REQUEST

Current Zoning: N1-A (neighborhood 1-A)
Proposed Zoning: N2-A(CD) (neighborhood 2-A, conditional)

Approximately 12.11 acres located on the south side of Sunset Road, east of Oakdale Road.

The petition proposes the development of up to 110 multi-family attached dwellings and 4 duplex lots. The property is currently the site of 2 single-family dwellings.

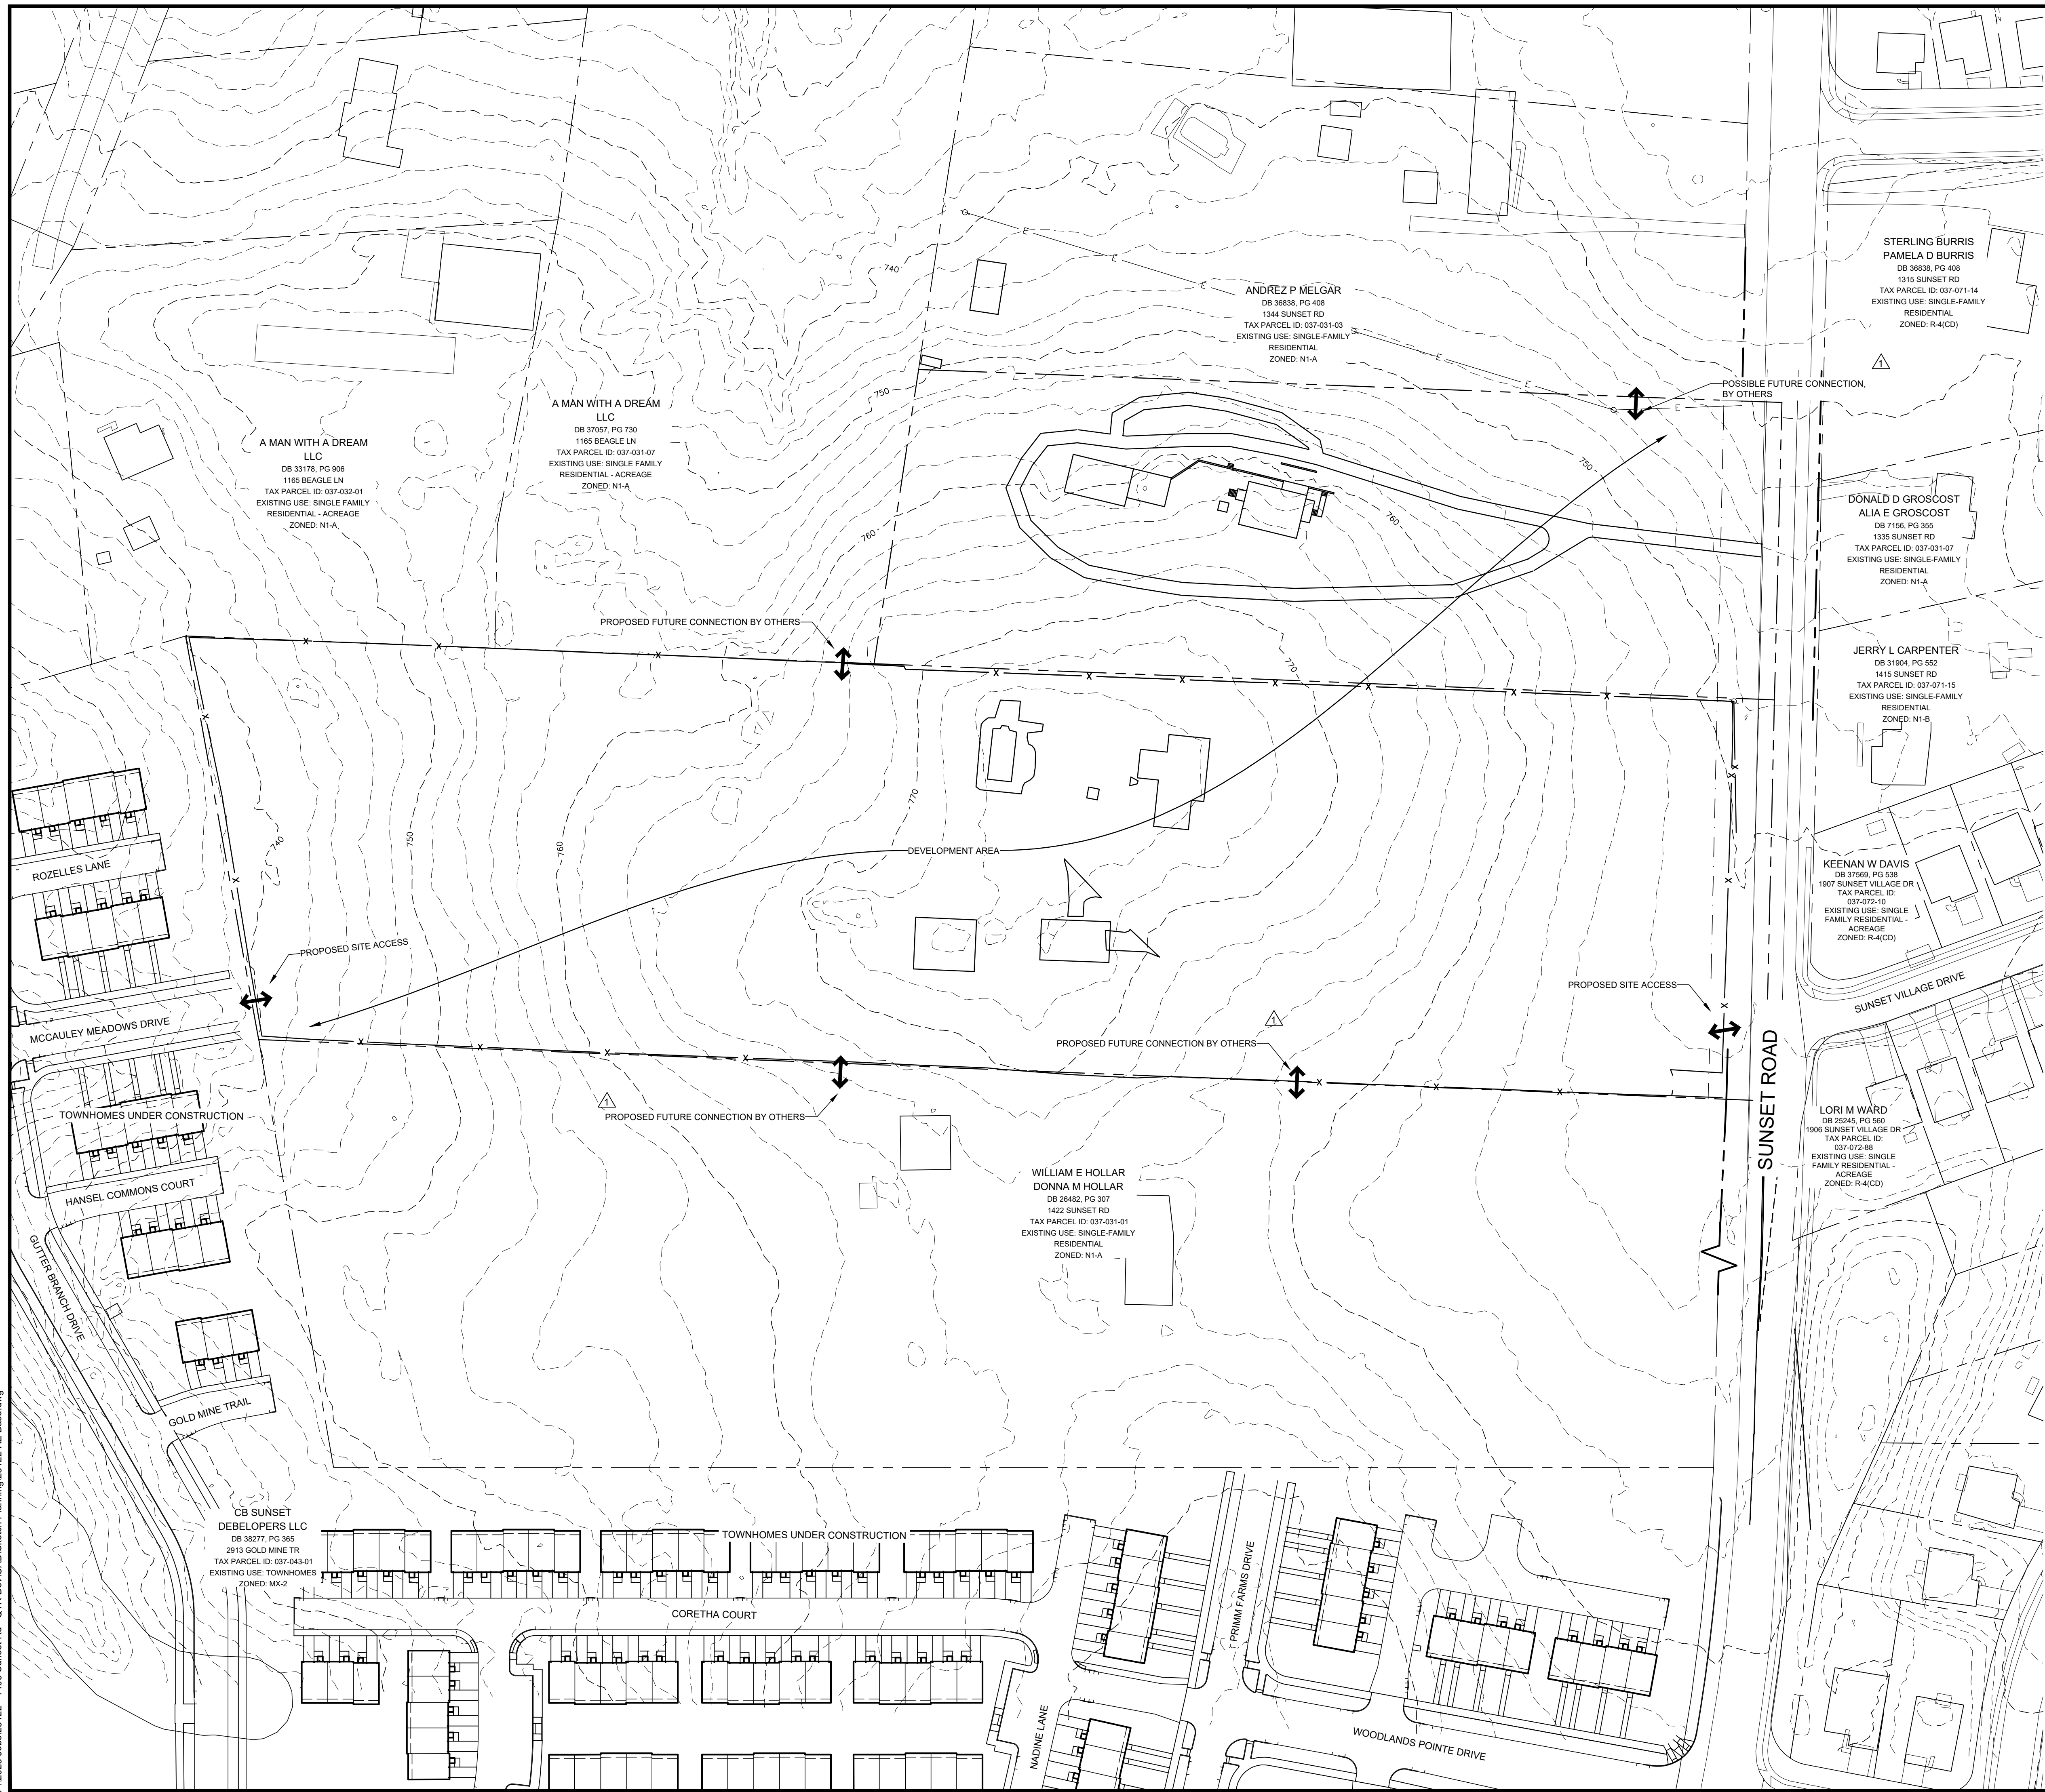
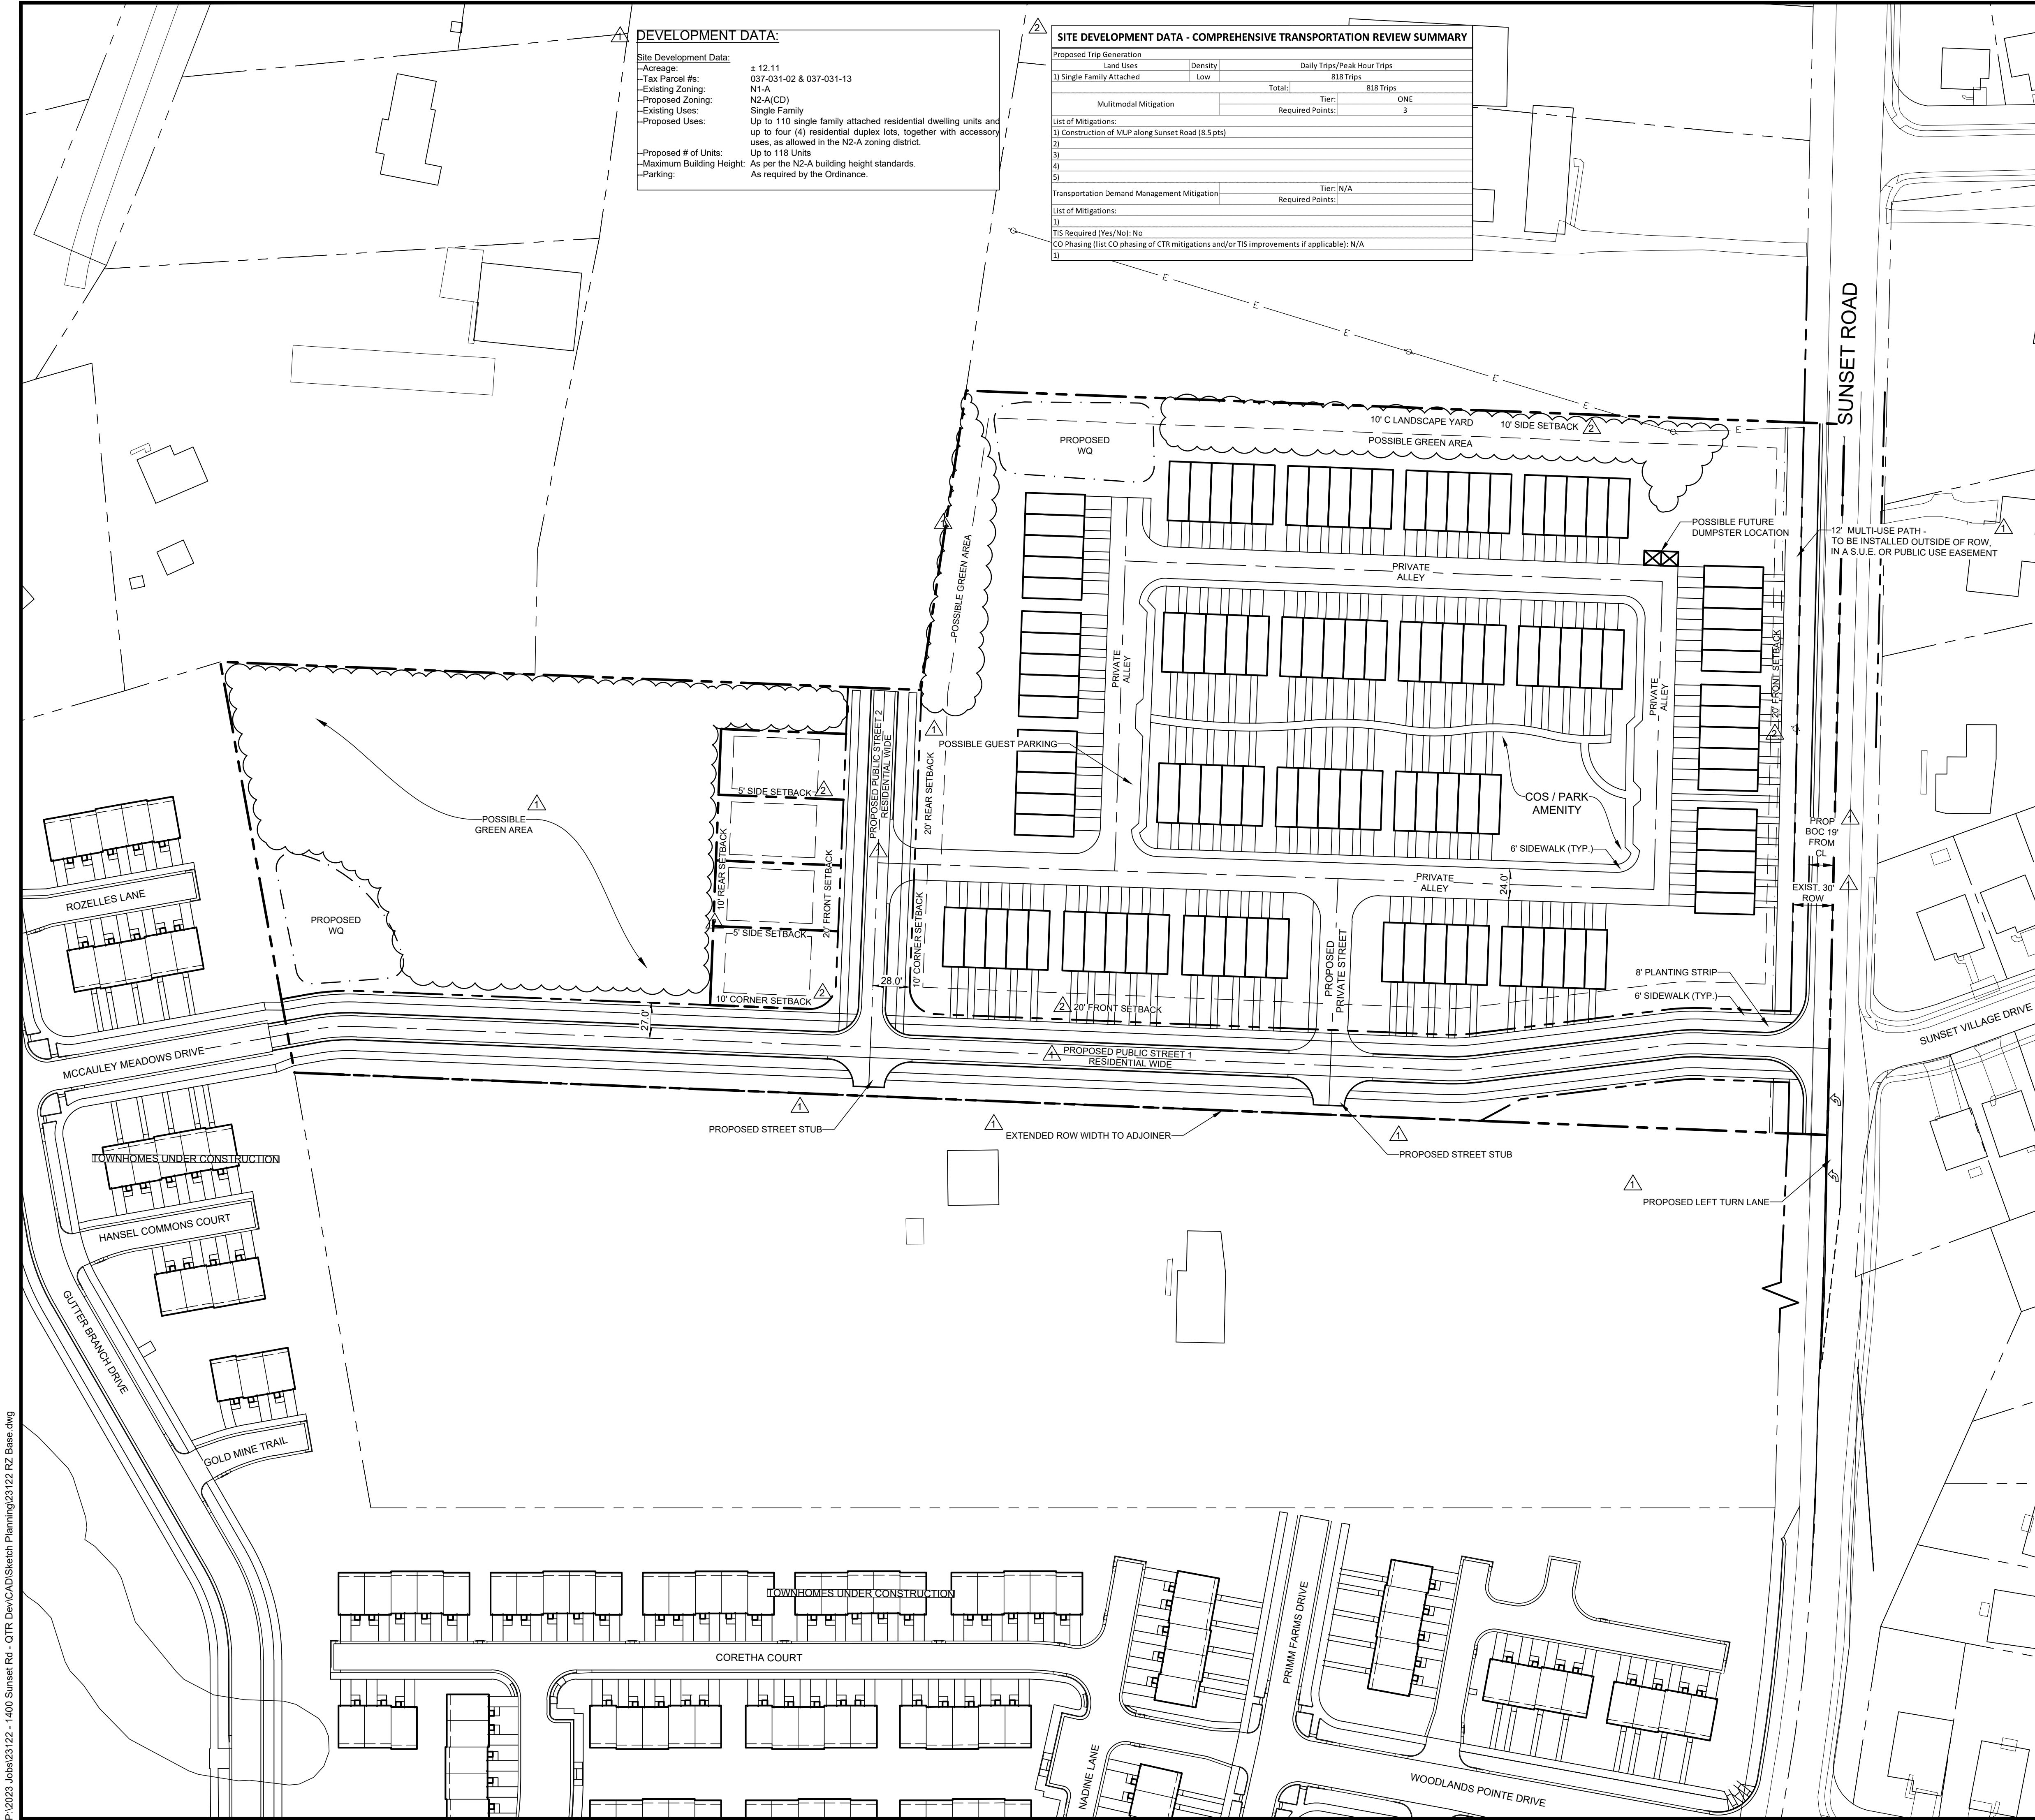
1. Revise site plan and conditional note(s) to commit to creating cross-access with the western (plan north) Parcel fronting Sunset Road per Article 31.2 in the UDO (See CDOT memo for diagram).
